The following comments are made on the North Irish Sea Array (NISA) Application on behalf of the Isle of Man Territorial Sea Committee:-

#### **Chapter 12 - Benthic Subtidal and Intertidal Ecology**

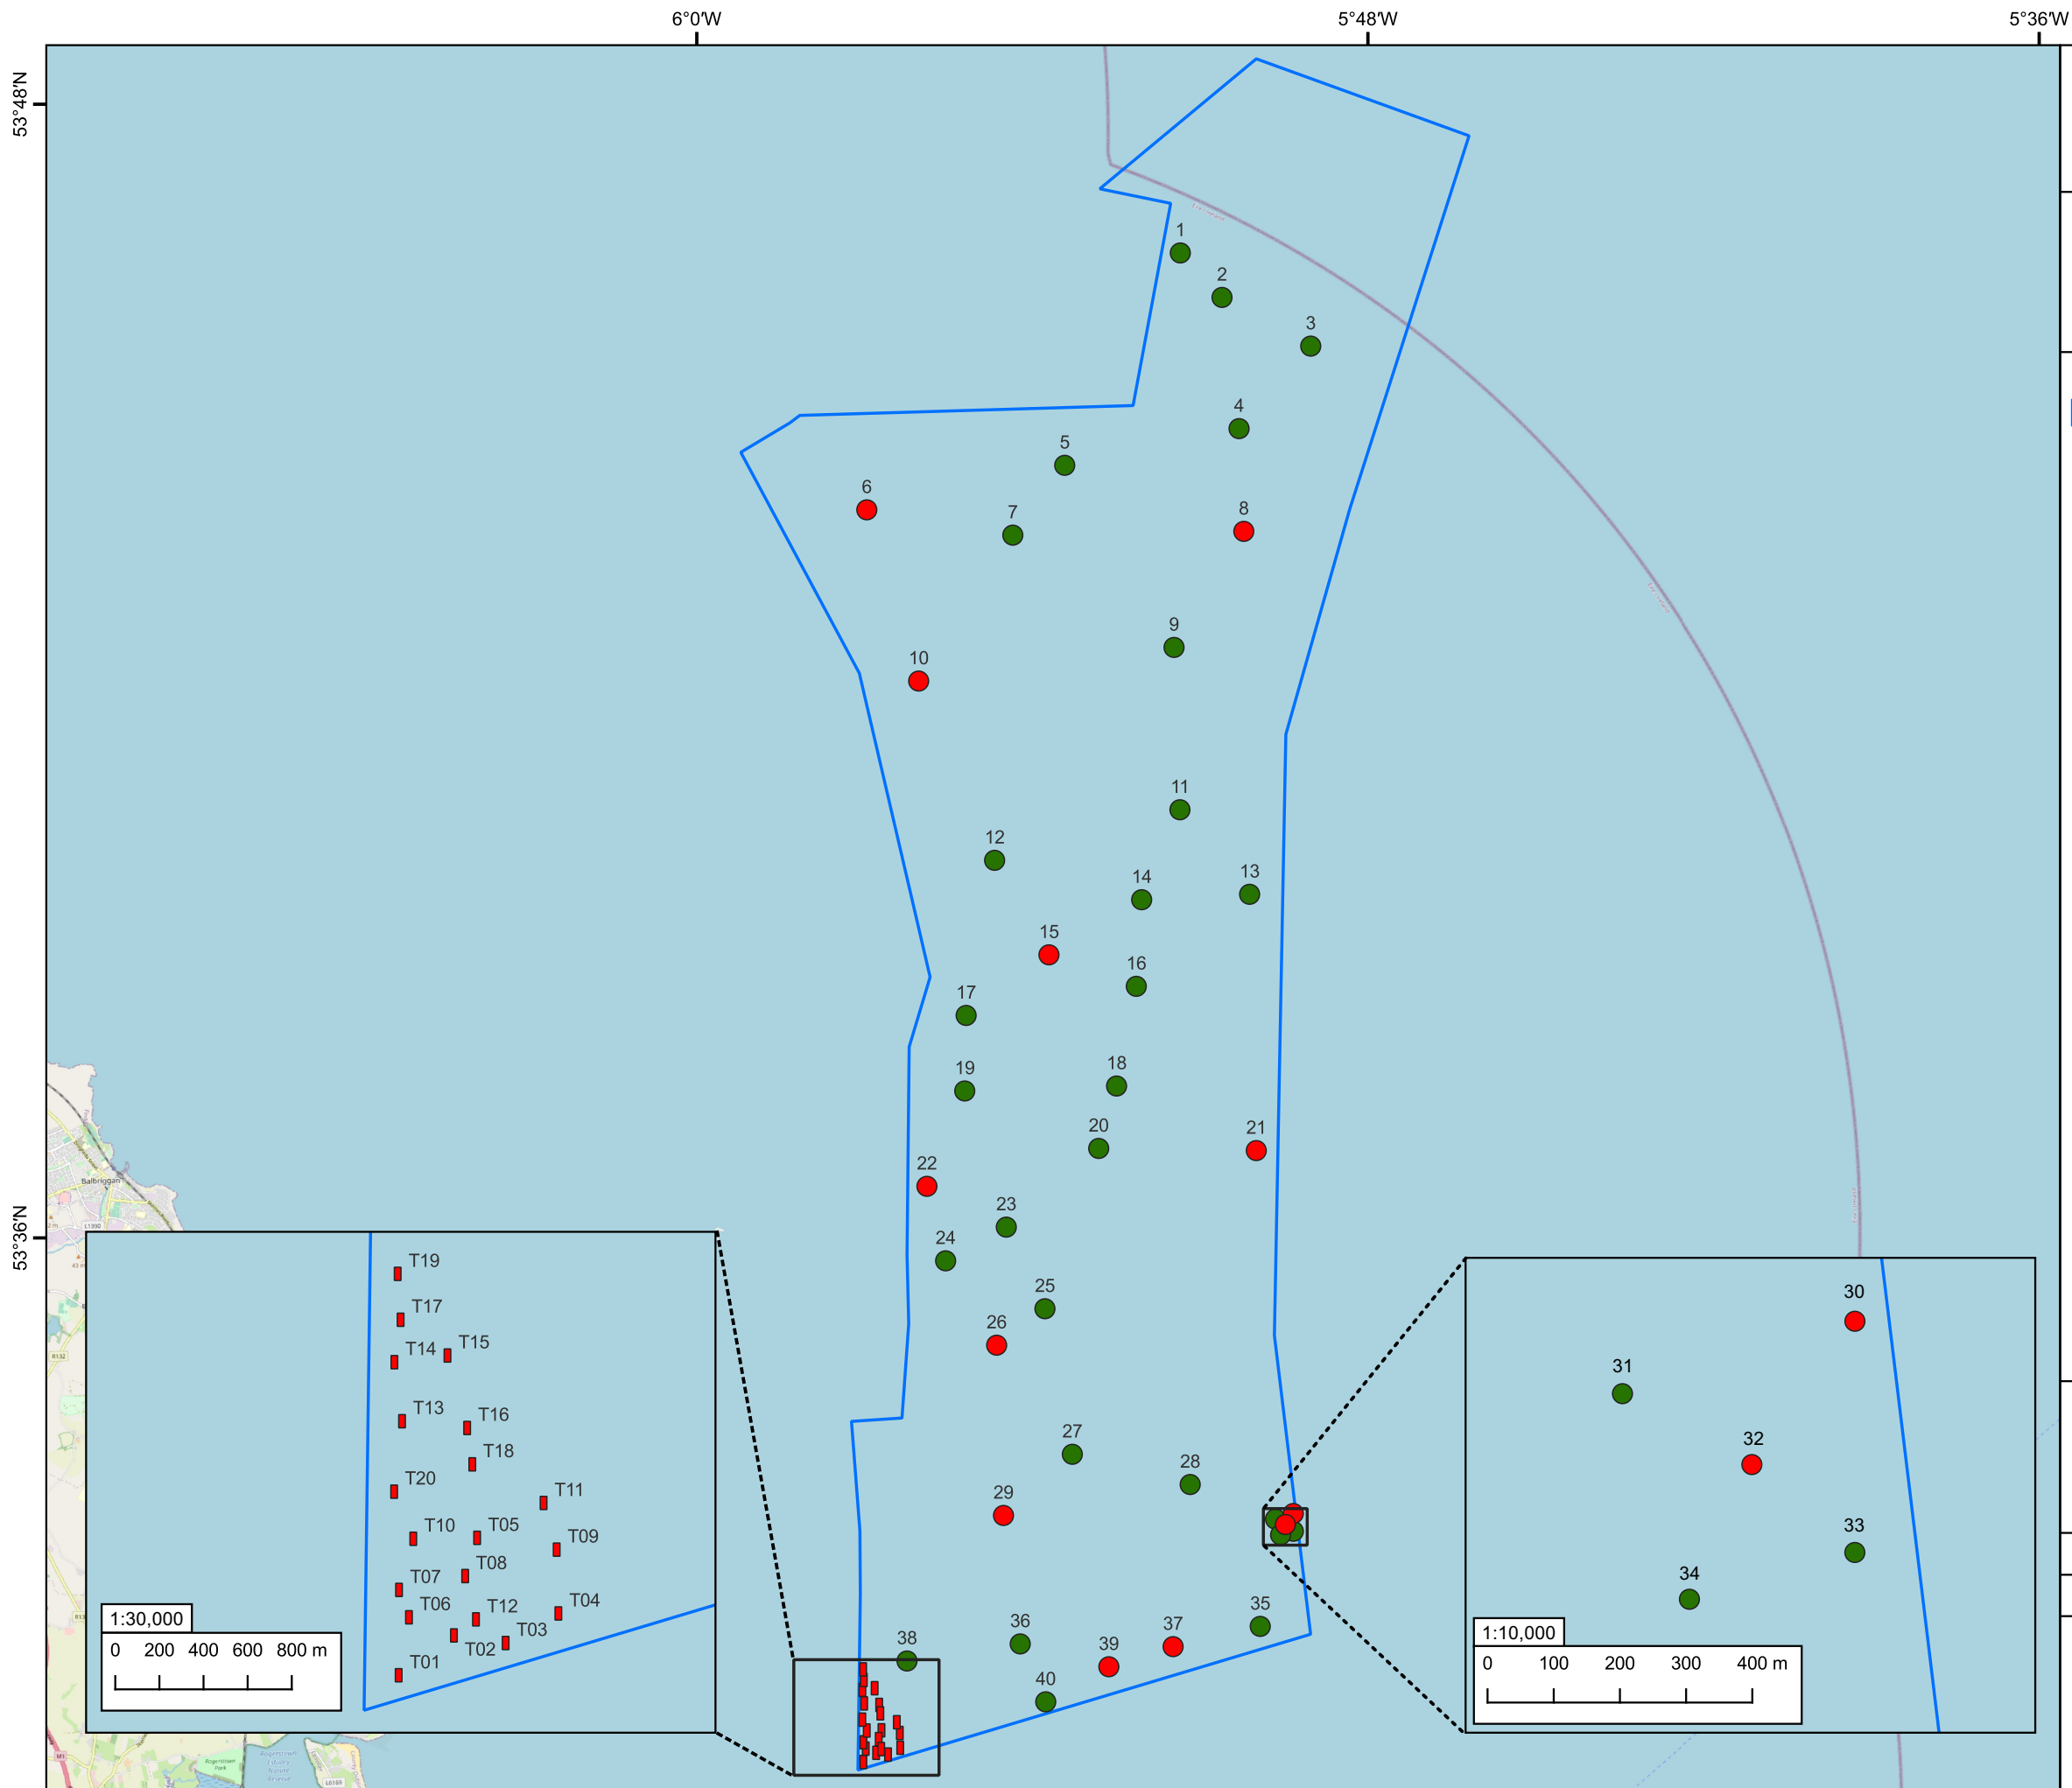
11. DP8 2.2. Survey Design. It is not very clear how the number and location of the sampling sites was determined. The report states a random stratified sampling approach but how does that actually

work? For example, why were two sites sampled 15 times while the other two were only sampled 5 times? I assume this is related to the size of the different habitats but it could be made clearer.

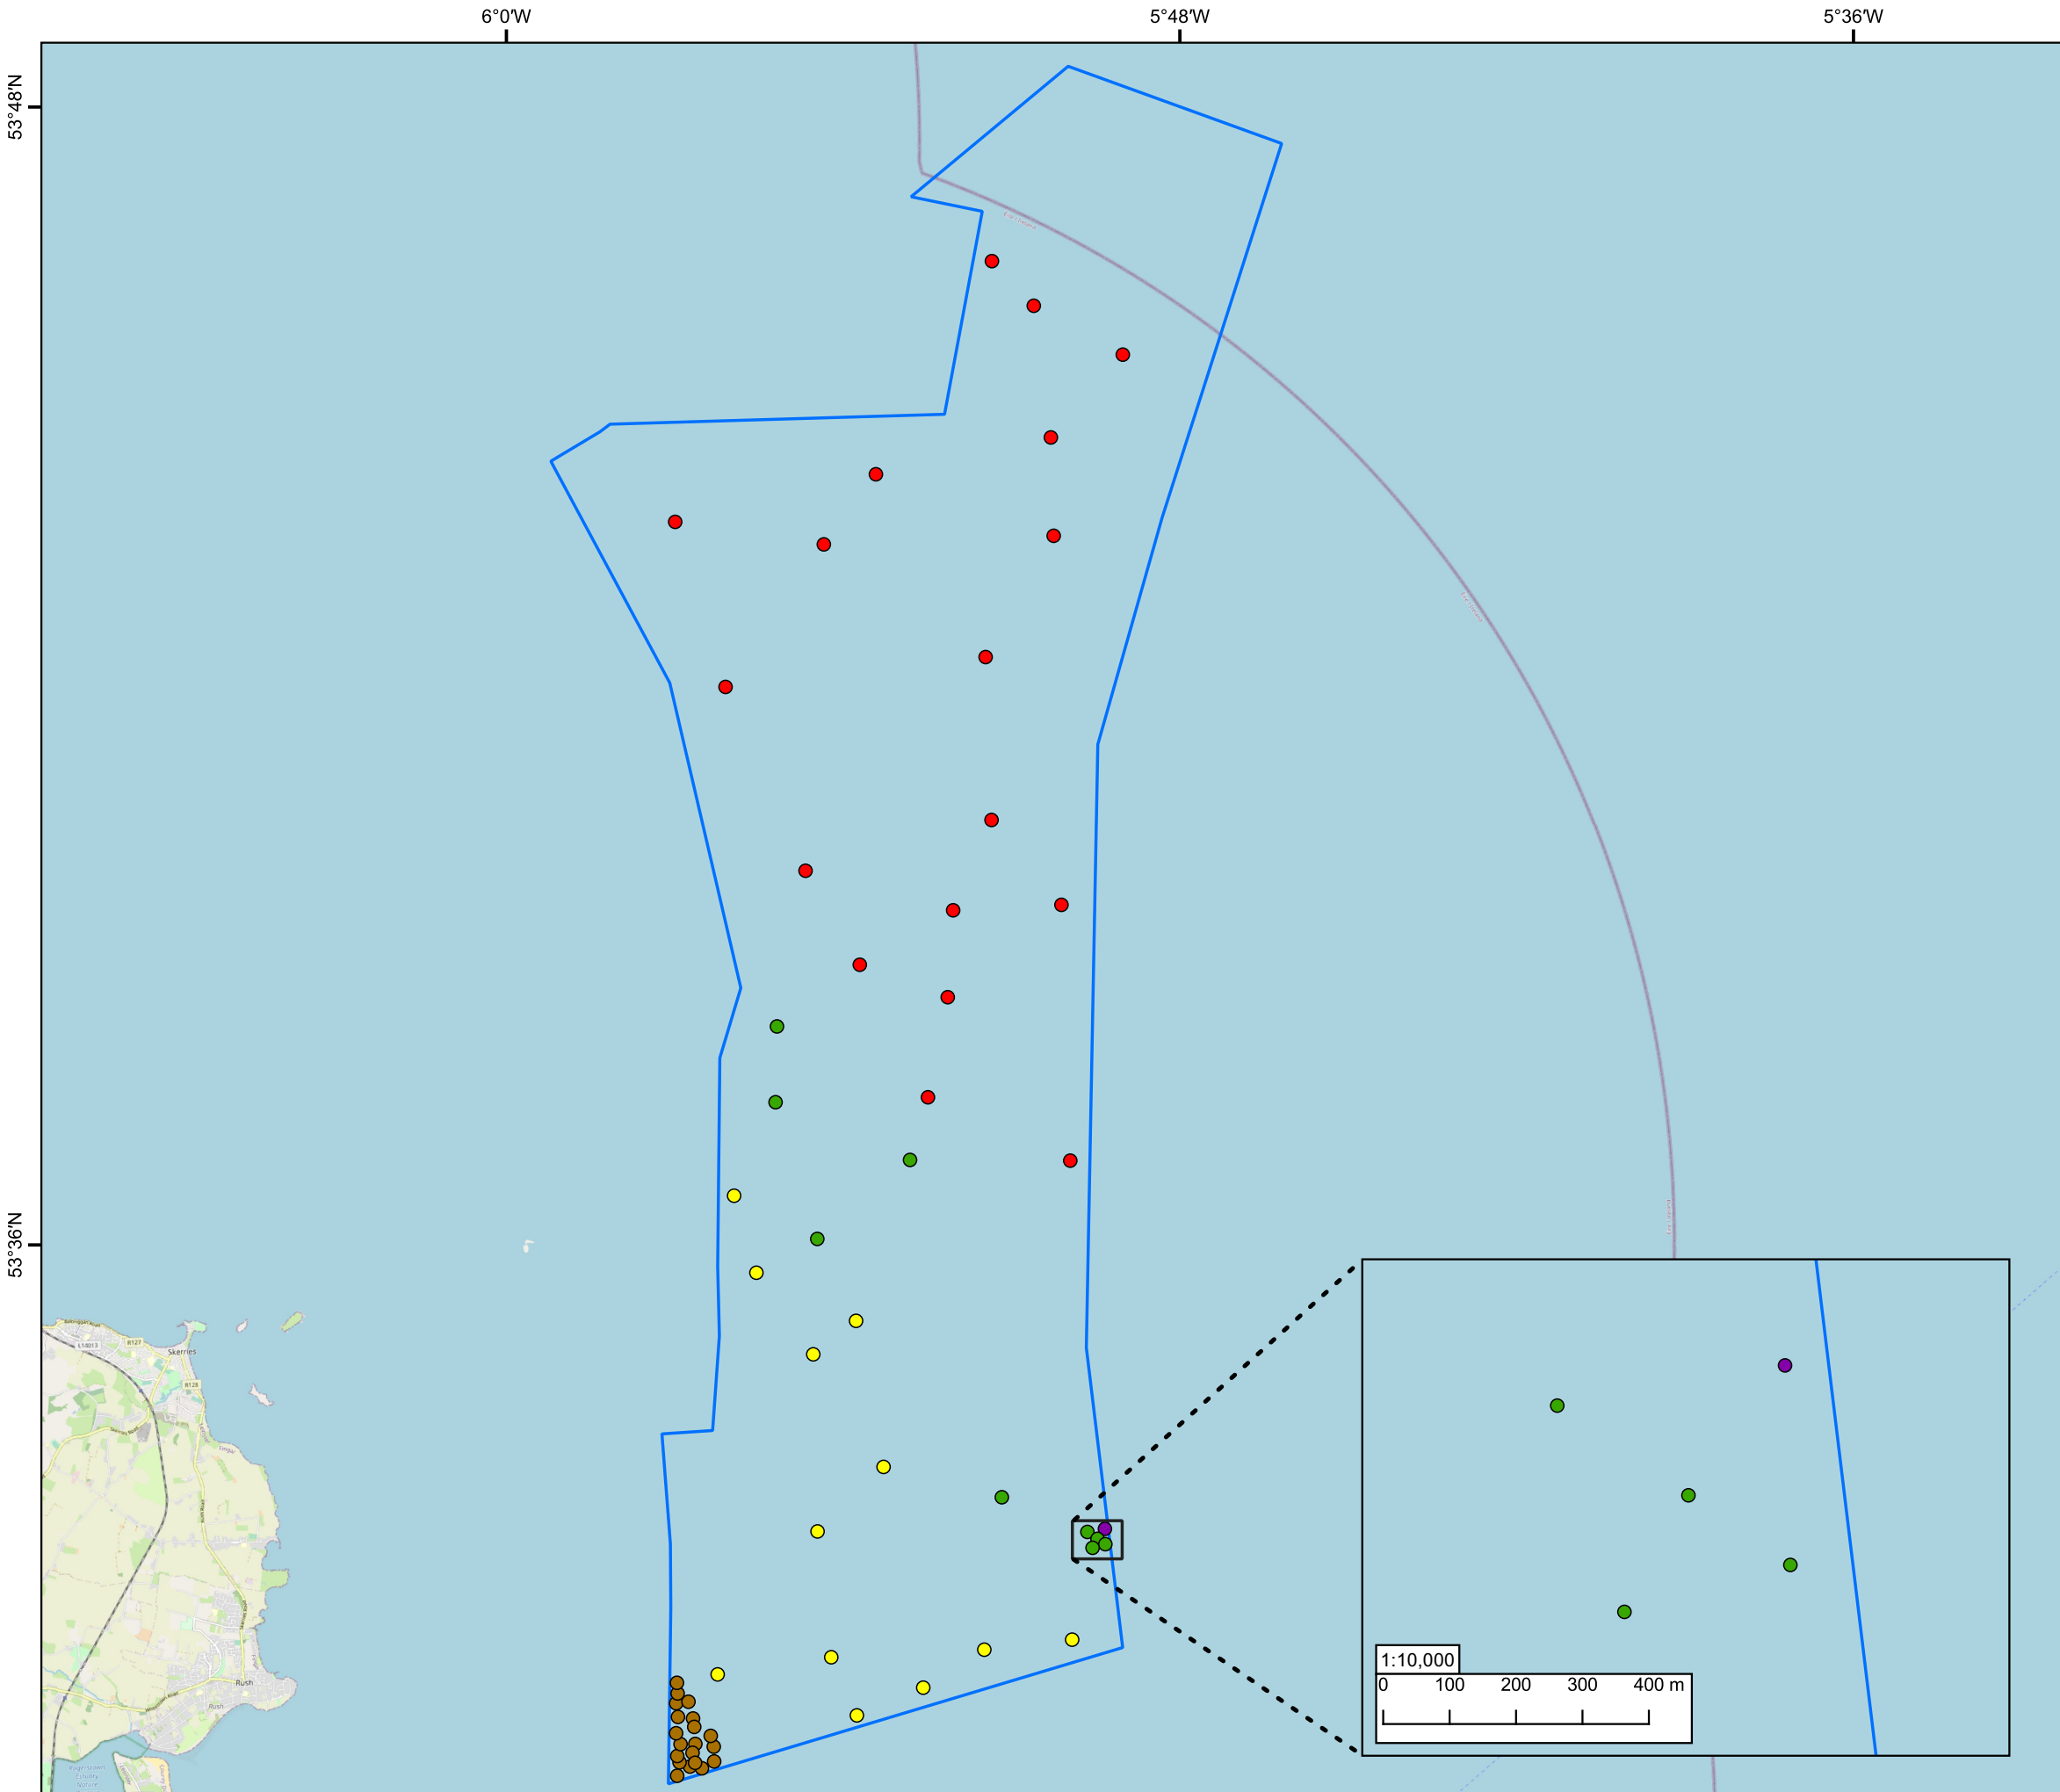
12. DP30 4. Discussion. The area stated as “seapens and burrowing megafauna in circalittoral fine mud” should be excluded from development i.e. monopiles should be sited away from that area.
13. General comment. Only the array area was surveyed so any assumptions made regarding the surrounding area e.g. the Zone of Influence (Zol) need to be viewed cautiously.
